Re: Laborer's Union-Phase I, 10001 Bell Ave SE,

Request for Permanent C.O. –Approved

Re: Laborer's Union, 10001 Bell Ave SE

Grading and Drainage Plan

ENGINEER'S SEAL RONALD R. BOHANNAN P.E. #7868	NEW MEXICO LABORER'S TRAINING FACILITY GRADING AND DRAINAGE PLAN TERRA WEST, LLC 5571 MIDWAY PARK PLACE NE ALBUQUERQUE, NM 87109 (505)858-3100 tierrewestllc.com	DRAWN BY DY DATE 04/27/11 2954-GRE SHEET # 1 JOB # 29054
---	--	--

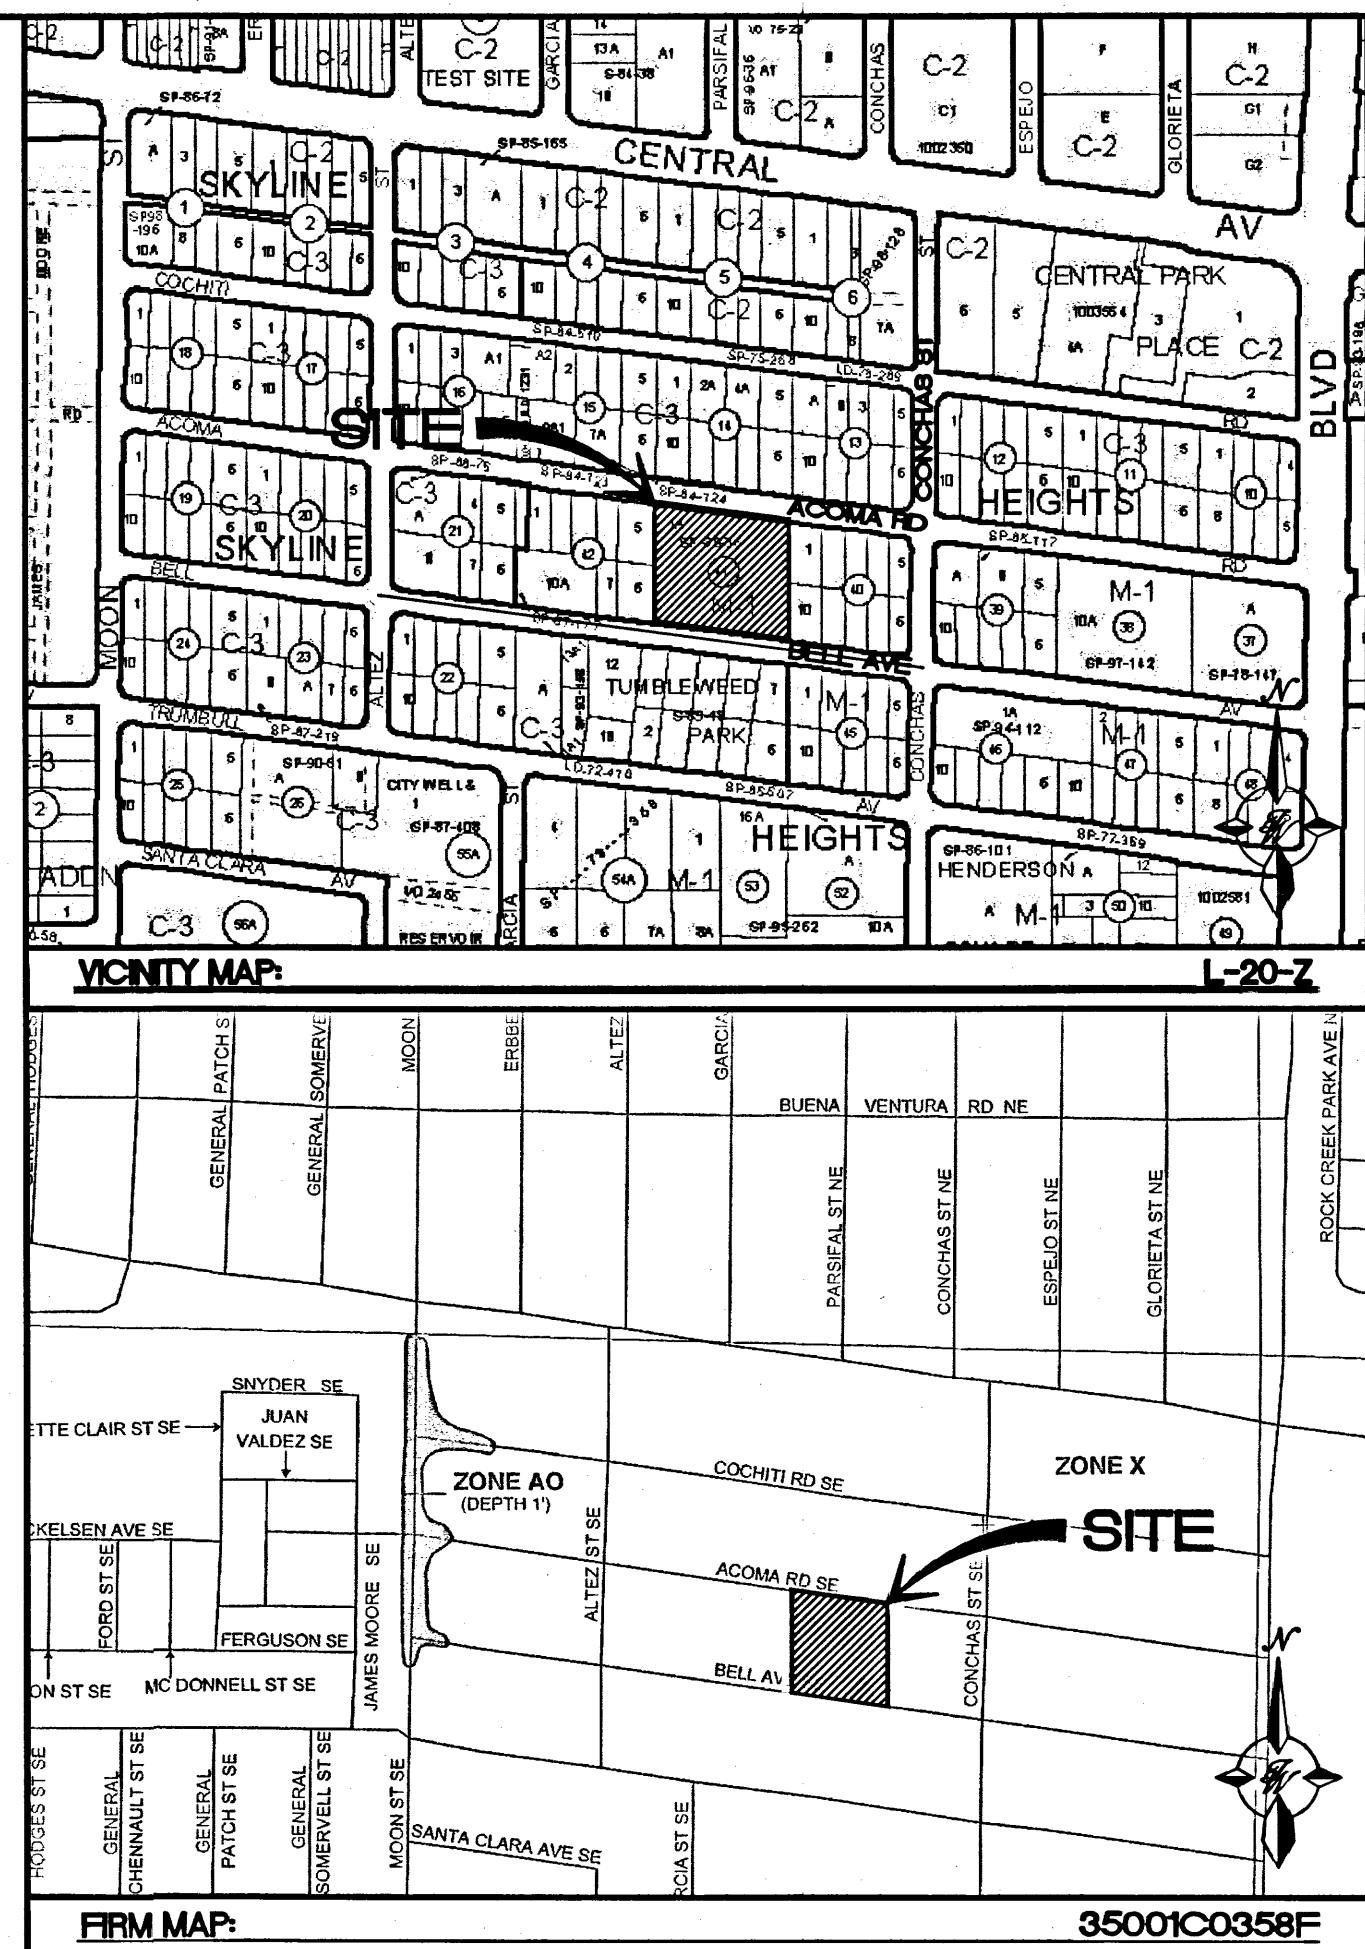
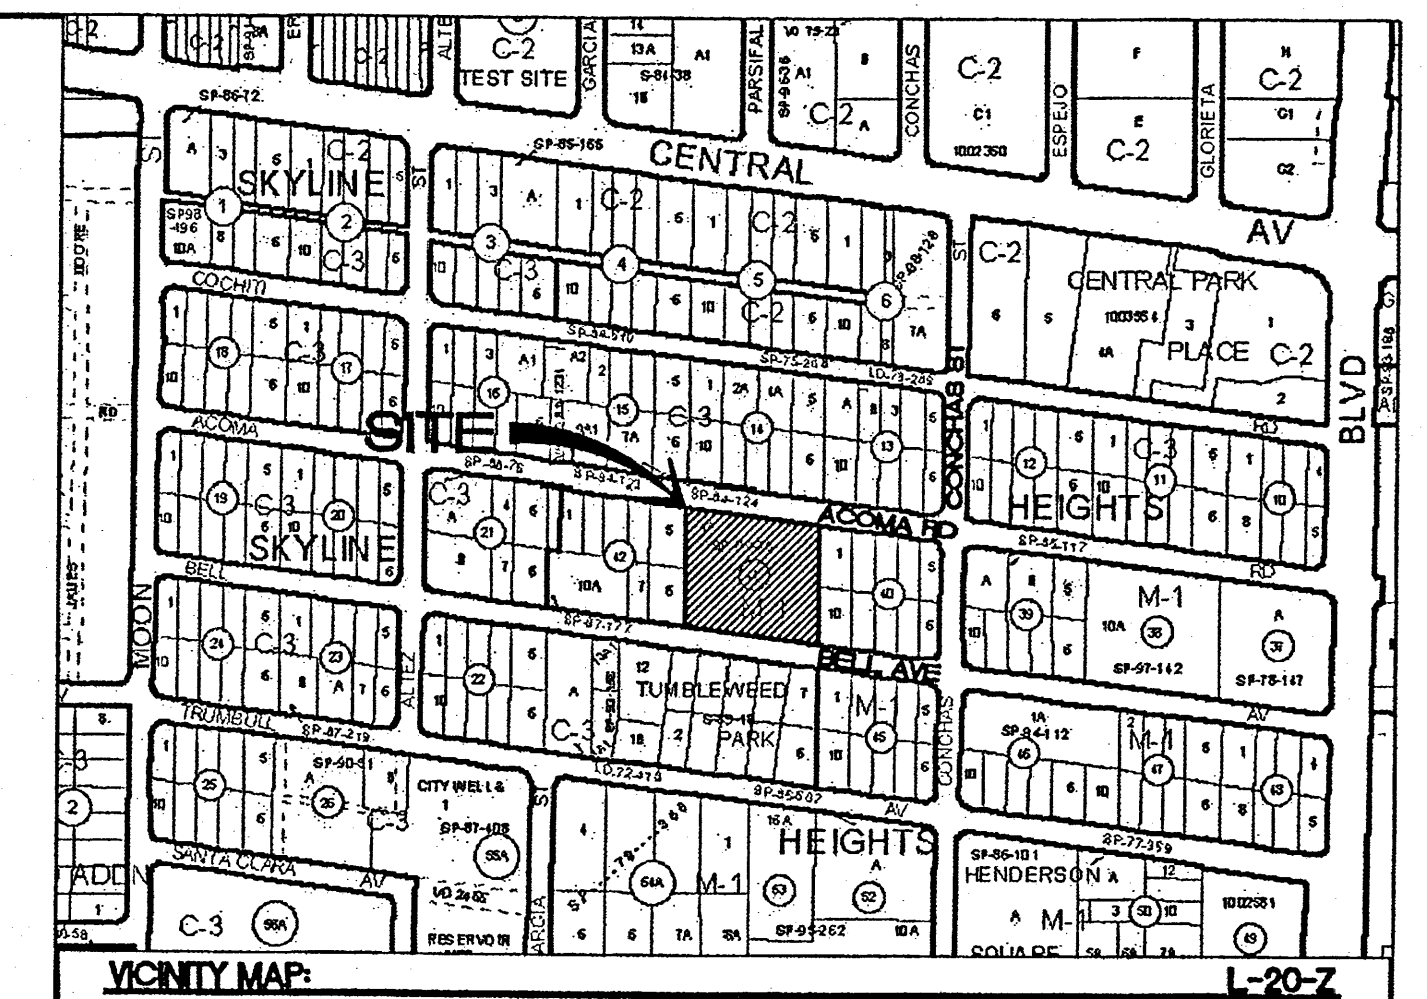
Based upon the information provided in your submittal received 4-28-11, the above referenced plan is approved for Building Permit and Grading Permit. Hydrology is requesting that proposed landscape areas be depressed to retain/infiltrate the rain that falls on them.

- A separate permit (SO 19) is required for construction within City ROW. A copy of this approval letter must be on hand when applying for the excavation/barricading permit. Please add the SO-19 notes to the plans.

- Are the contours according to the datum 29 or 88?
- We would like to for all landscaped areas to be depressed. If at all possible, can the flows from the parking lots flow through the landscape areas before entering the streets.

- We are trying to avoid sidewalk culverts as much as possible. We would prefer for the flows to exit via the driveway in the Southwest corner of the lot or tie the 6" and 10" PVC into the back of the inlet on Bell Ave. or extend the PVC piping under the sidewalk.

- What types of inlets are being used? A detail is needed for these inlets.
- The 34ft 3" SCH40 at the north side of the building should not drain into the handicap parking.

- Show direction of flow from buildings.
- Are elevations at east end of parking lot top of curb?
- Include offsite flows from the "small area" in your calculations.

- Show public inlet capacities and amount of flow towards each from the site. (Items with strike through discussed with consultant on 3/31/2011)

SO-19 notes were added to the grading plan sheets.

Then contours shown reflect data from a topographic survey prepared by Russ P. Hugg (NMPS No. 9750) in January 2010 based upon the Albuquerque Control Survey Benchmark "5-K20", Elevation =5429.995 (NAVD 1988). We added a "Project Bench Mark" to the grading plan for reference during construction. Enclosed is a reduced copy of the ALTA for your use/file.

- 3. We would like to for all landscaped areas to be depressed. If at all possible, can the flows from the parking lots flow through the landscape areas before entering the streets. We revised the plans to include curb cuts and depressed landscape areas in the parking lot islands, as requested.

We revised the plans to connect the private area drain system into the existing storm inlet per City Standard Drawing No. 2237, as discussed during our meeting.
- 5. The 34ft 3" SCH40 at the north side of the building should not drain into the handicap parking.

We revised the location of the drain west of the ADA accessible parking space.

NEW MEXICO LABORER'S  
TRAINING FACILITY  
TRAFFIC CIRCULATION  
LAYOUT  
TIERRA WEST, LLC  
5571 MIDWAY PARK PLACE NE  
ALBUQUERQUE, NM 87109  
(505)858-3100  
tierrawestllc.com

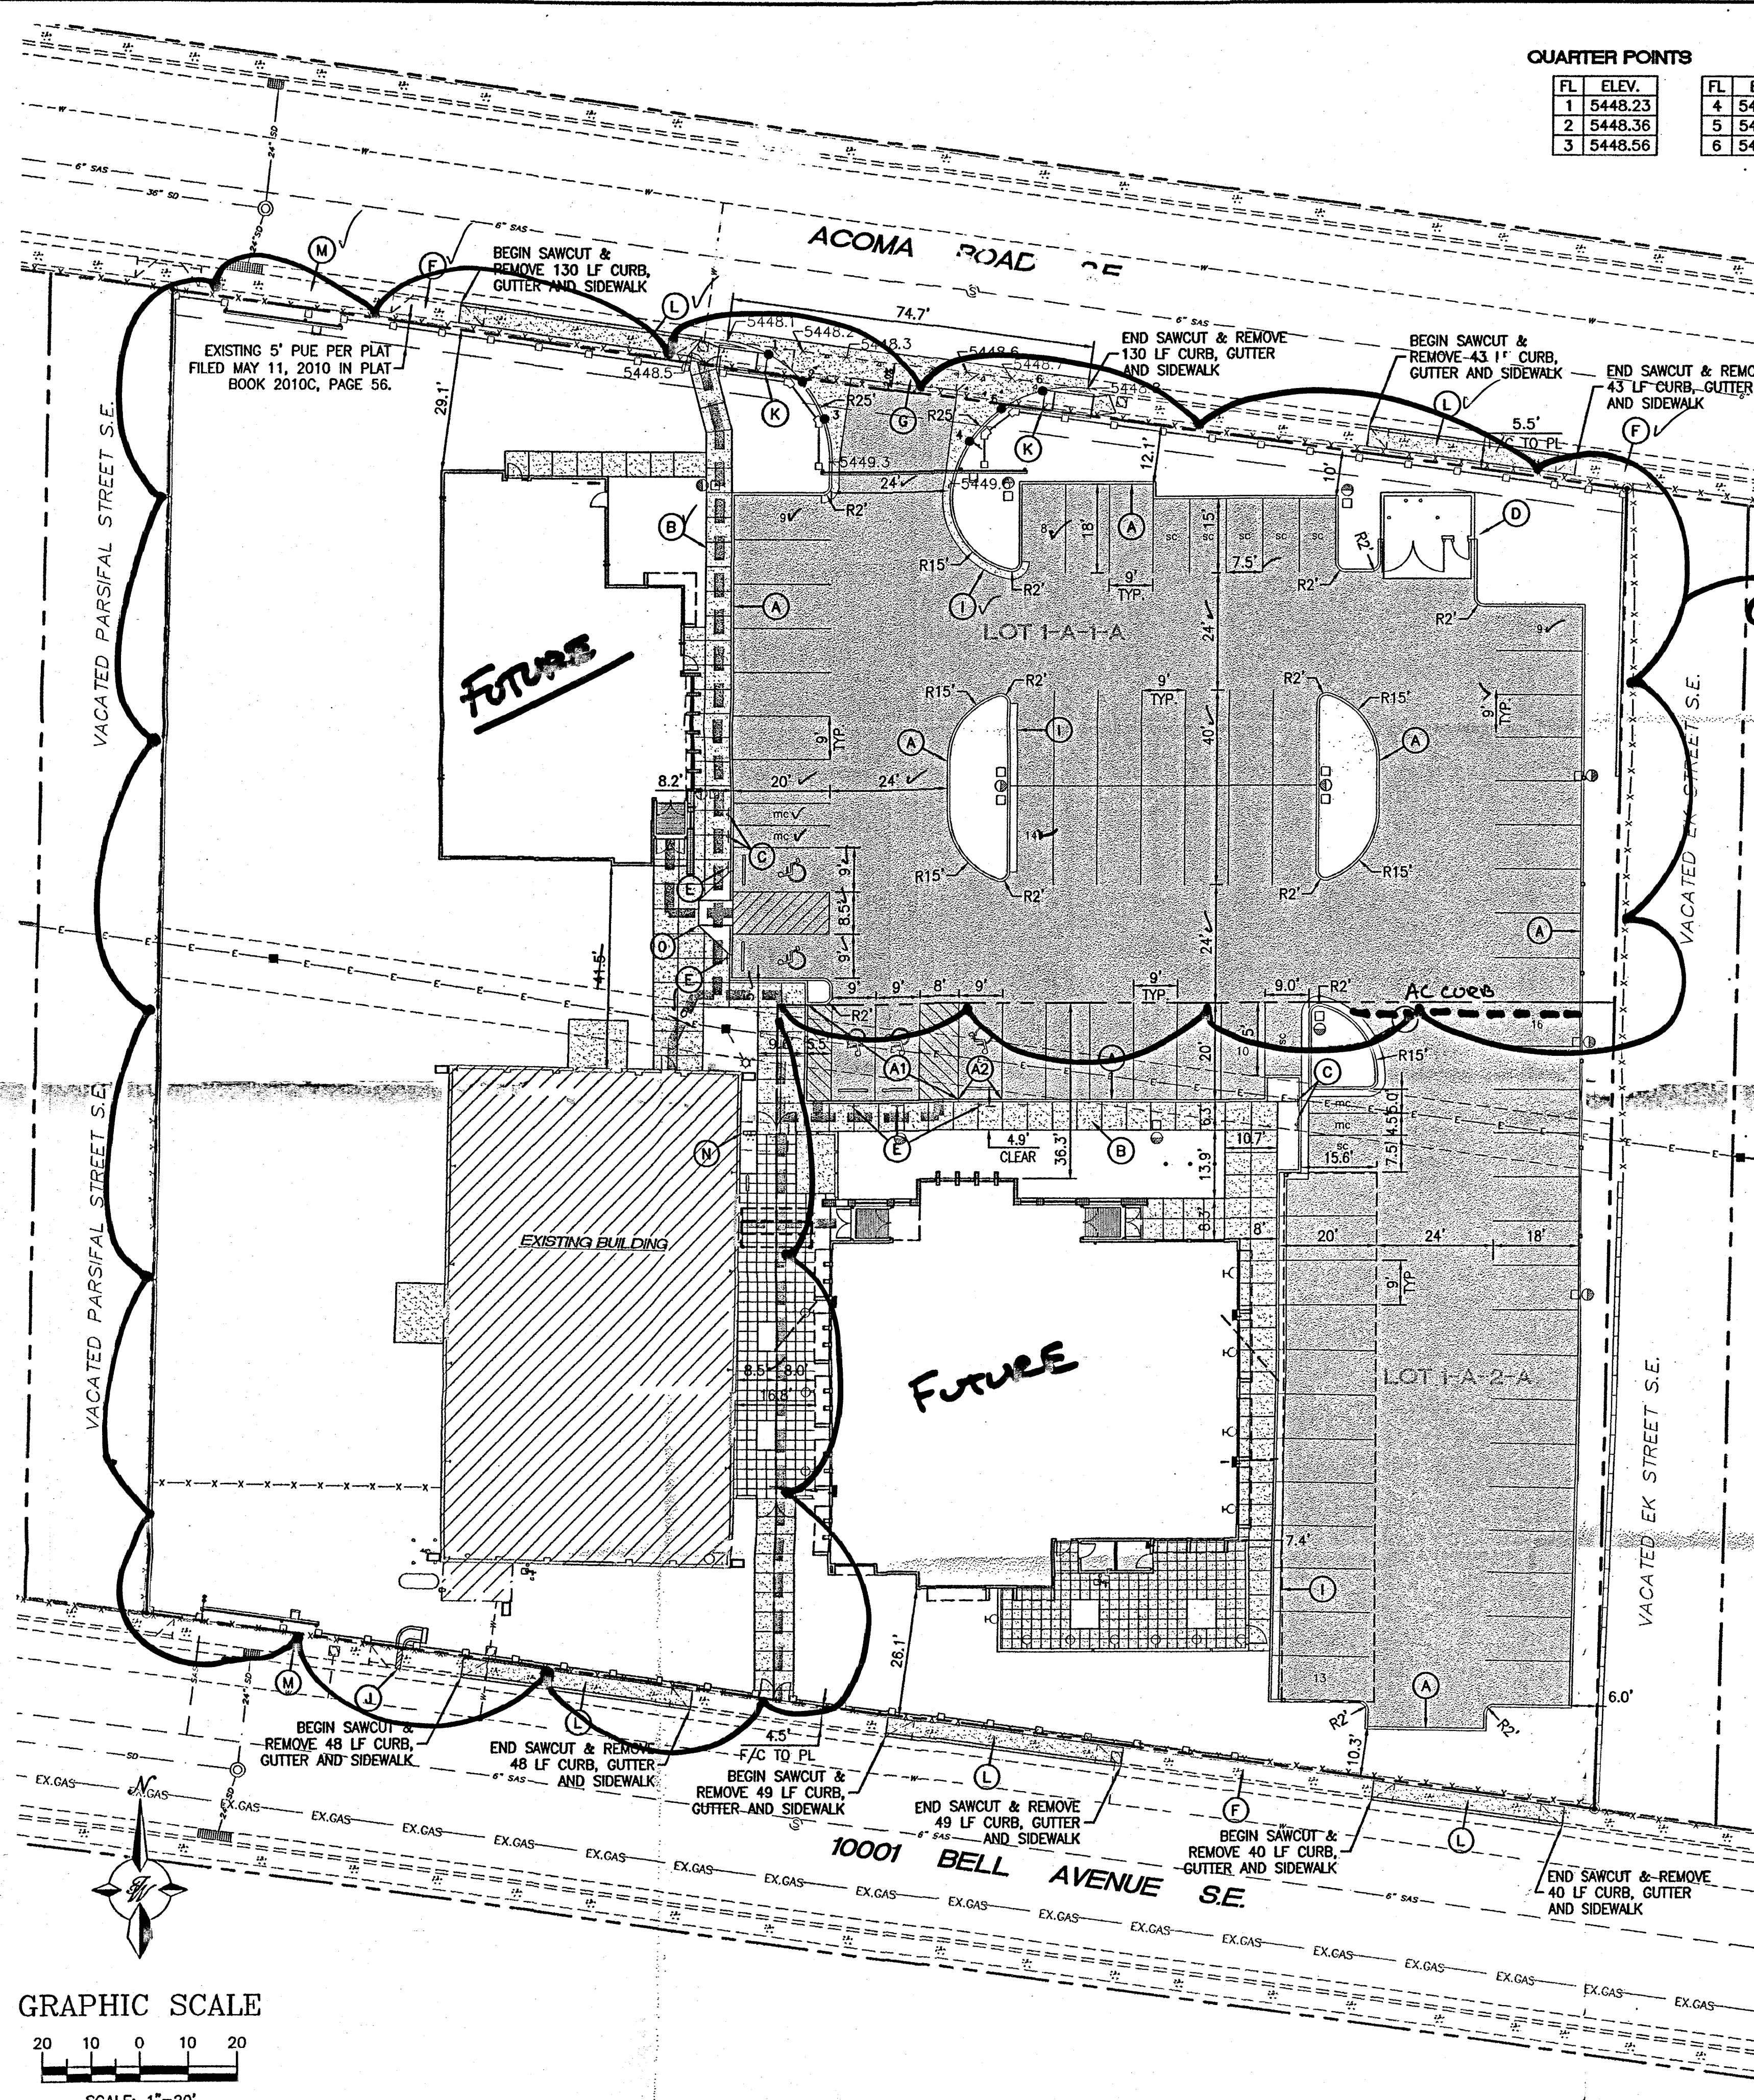
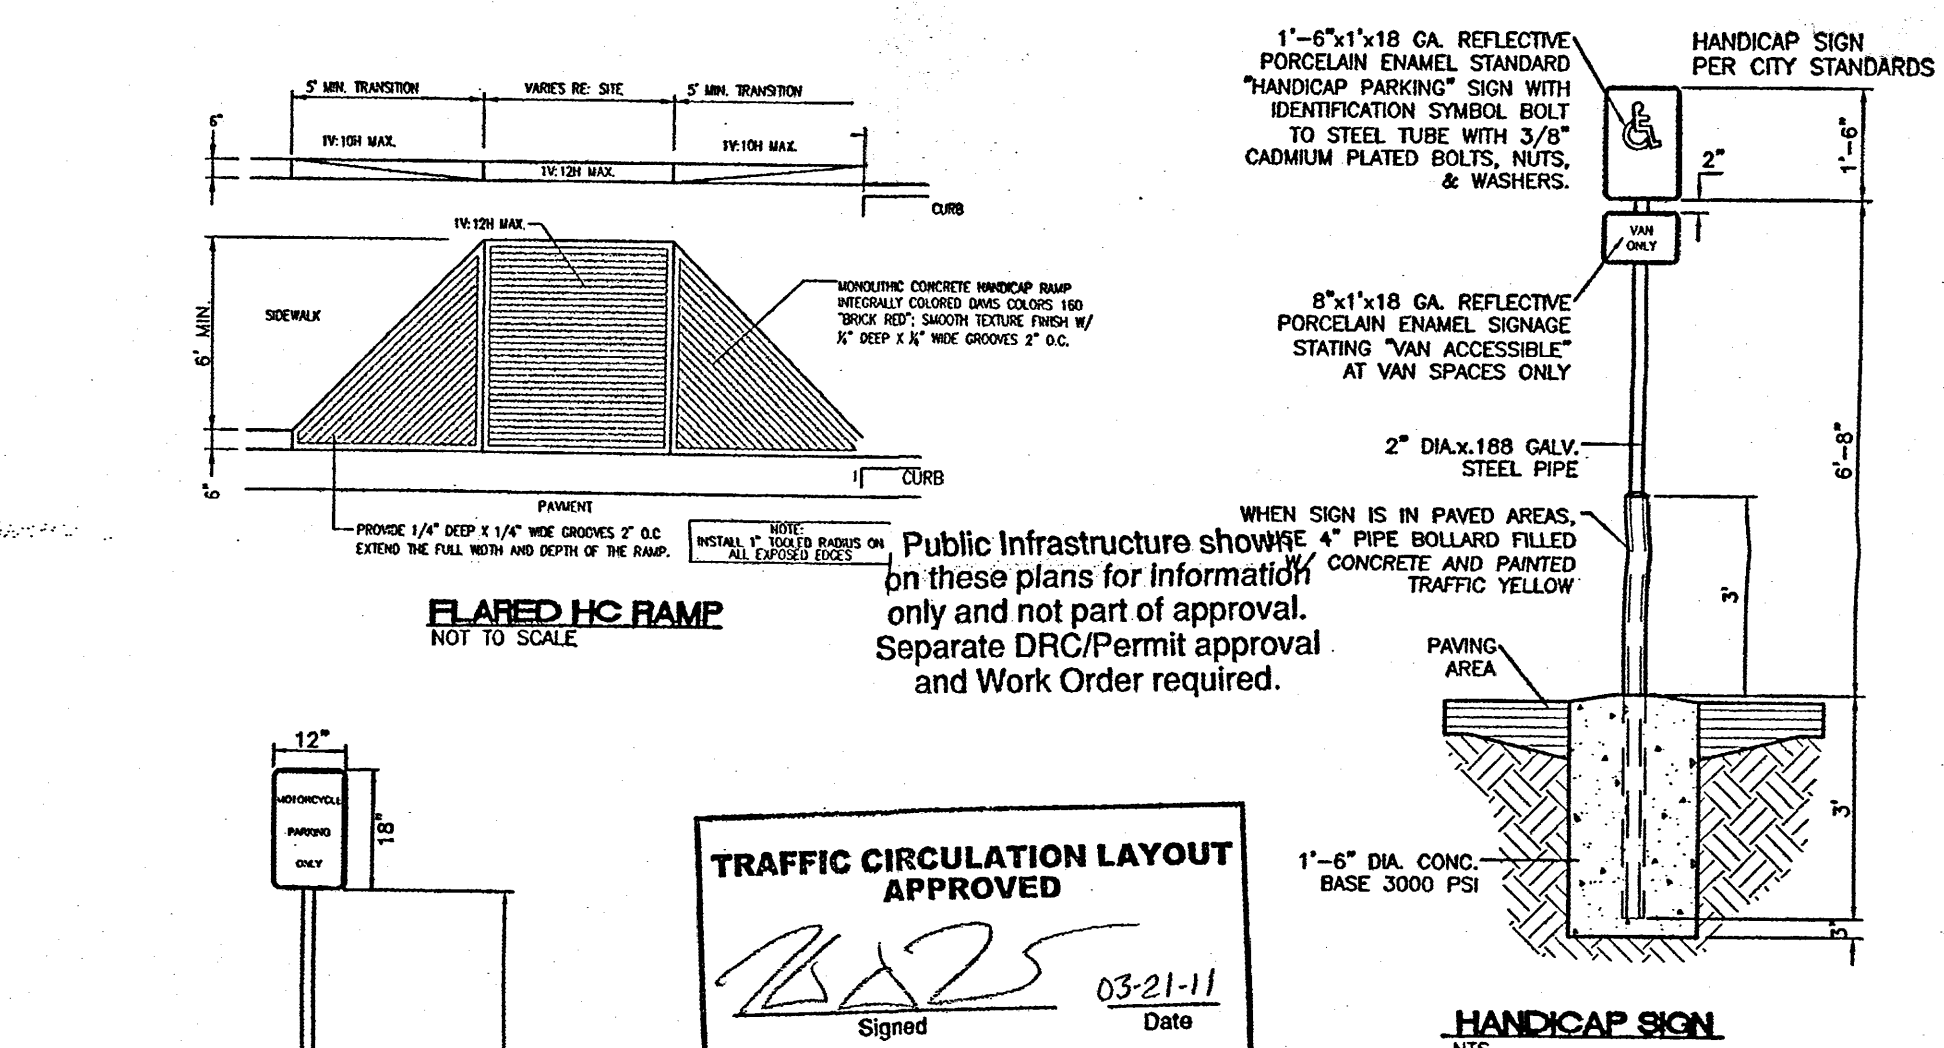
- Proper certification of the approved Site Plan (Traffic Circulation Layout approved 03/21/11). The submitted copy (sheet AS-101) along with the approved copy are different from each other and will need clarification as to which one of the site plan is being certified.
- Provide a recorded copy of the cross access easement between lot 1A1A and lot 1A2A (a condition that was specified at the building permit approval process for Traffic Circulation Layout plan).

Provide a recorded copy of the cross access easement between lot 1A1A and lot 1A2A.

- 1. Call out the width of the proposed keyway.
- 2. Please include two copies of the traffic circulation layout at the next submittal.
- 3. Clarify what is proposed south of the existing building. Is this a new curb cut?

- 4. List the number of parking spaces required by the zoning code as well as the proposed number of parking spaces.
- 5. Call out the width of the western access aisle for the handicapped parking space.

- 6. Define width of all sidewalk, existing and proposed.
- 7. All curb cuts that are no longer in use must be removed and replaced with sidewalk and curb and gutter (see the *Development Process Manual*, Chapter 23, Section 6.B.17.). Six unused curb cuts are shown along this site's frontage. They must be removed at this time.

- 8. Provide build notes for all items proposed within City right of way (sidewalk, curb and gutter, curb cuts, etc.).
- 9. All sidewalk within the site must be a minimum of 6 feet wide.

- 10. Show the ADA pathway from the handicapped parking stalls to the building. Show all ramps and provide details.

- 1. Call out the width of the proposed keyway.
- 2. Show the ADA pathway from the handicapped parking stalls to the building. Show all ramps and provide details.
